From: Amanda Scholes on behalf of Planning.Responses
Sent: 08 June 2020 11:53
To: Planning Scanning
Subject: FW: 2020-05-15-19163-PARCELS A2 & B6, Littlehampton - Drainage Drawings

Paul Cann
Principal Drainage Engineer
Engineering Services

Comments;

Hydro-Brake Control Chamber HB2

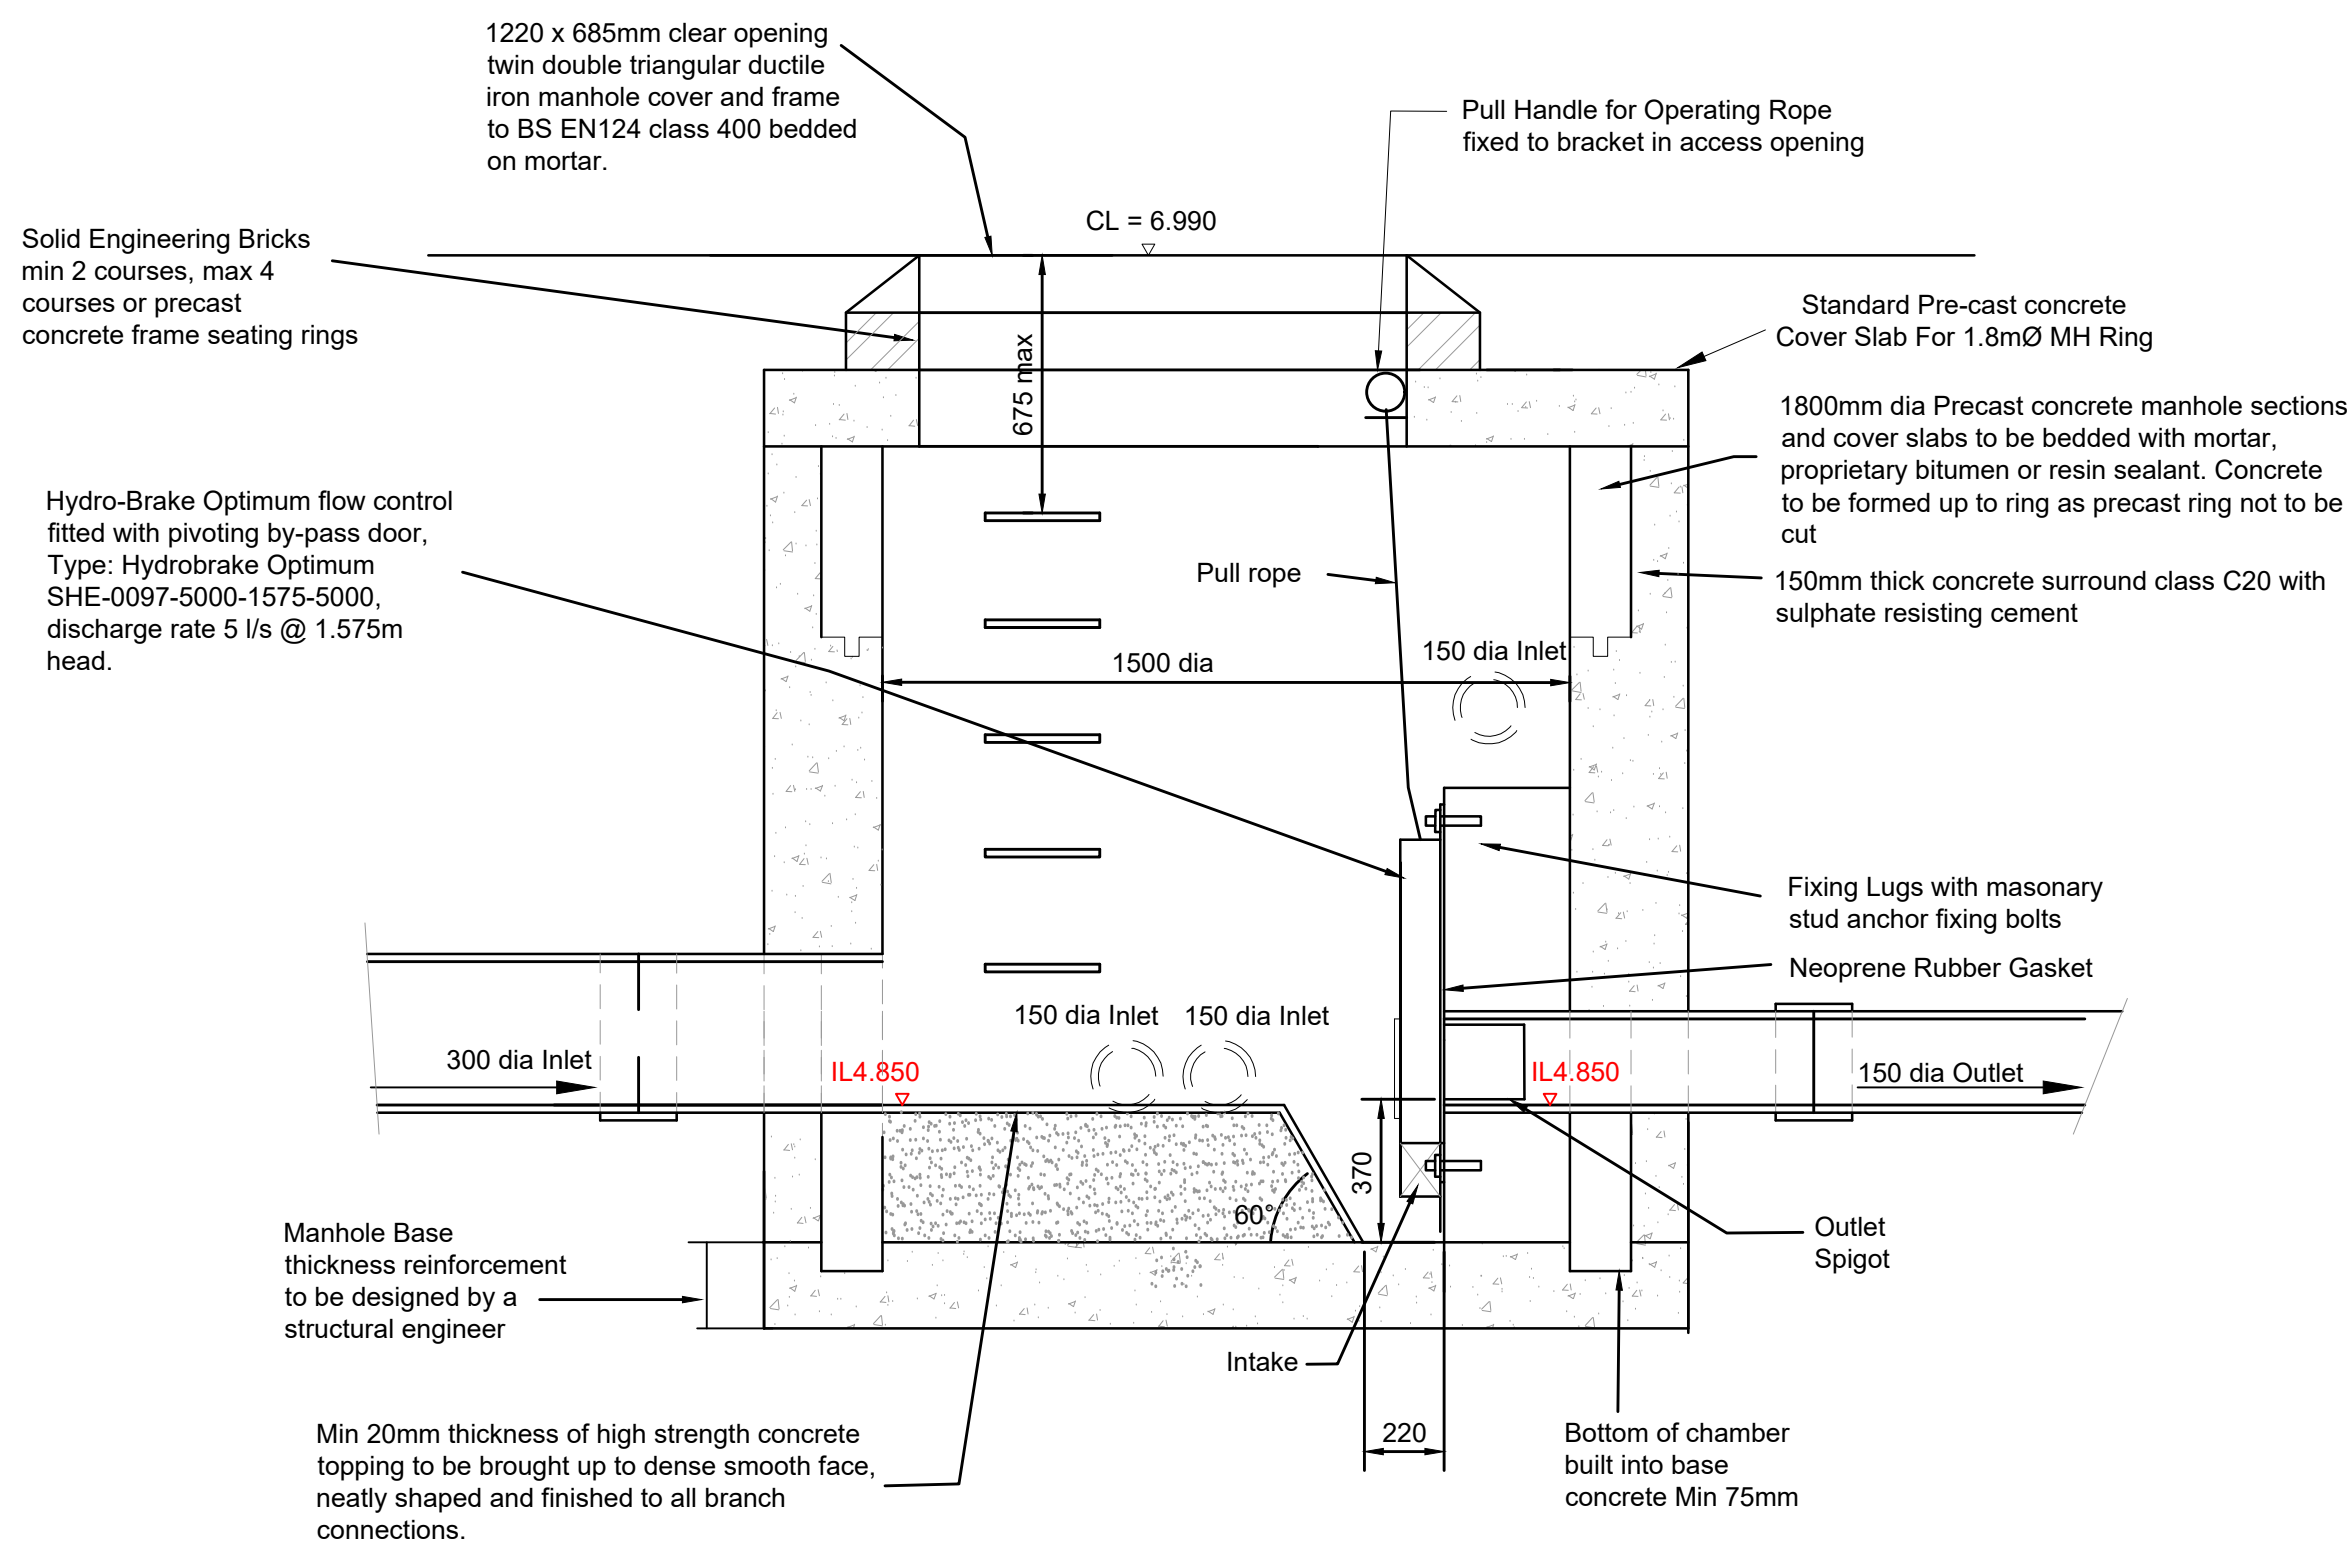
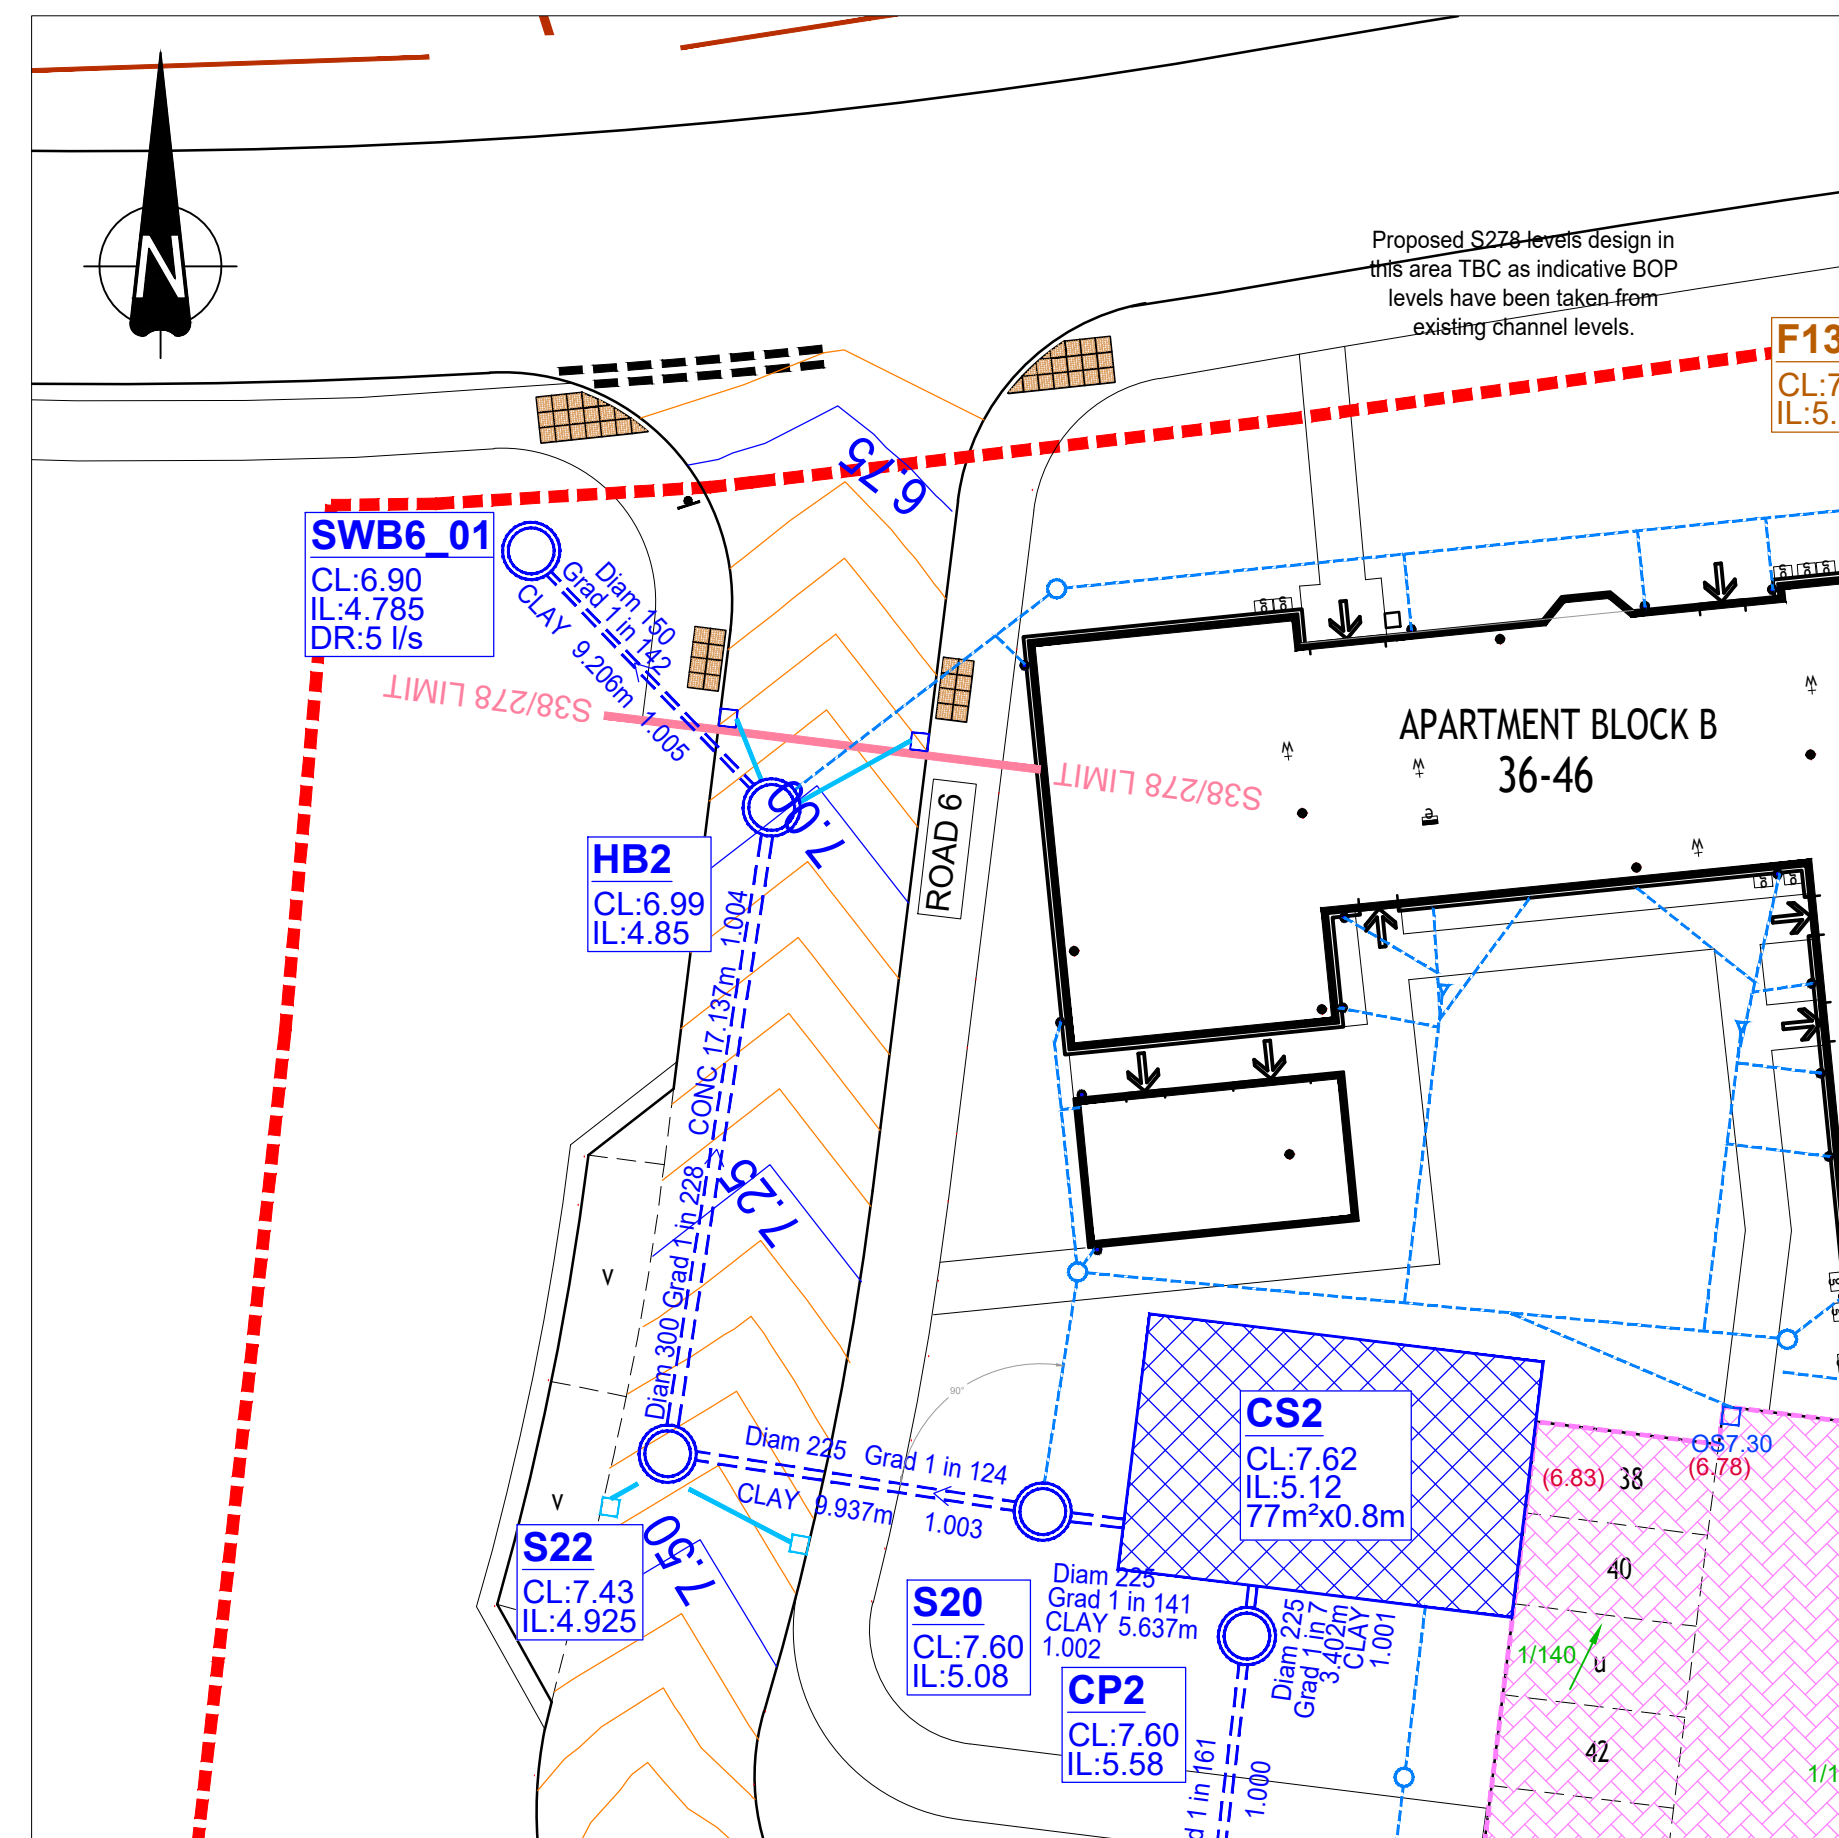
6. Both hydrobrake chambers – show base thickness/reinforcement details. *ok*
7. Existing manhole SW03A – just upstream of SWA2_01 – what is its purpose? Invert level is lower than the downstream manhole. Please clarify if it is required and adjust as necessary. *Removed - ok*
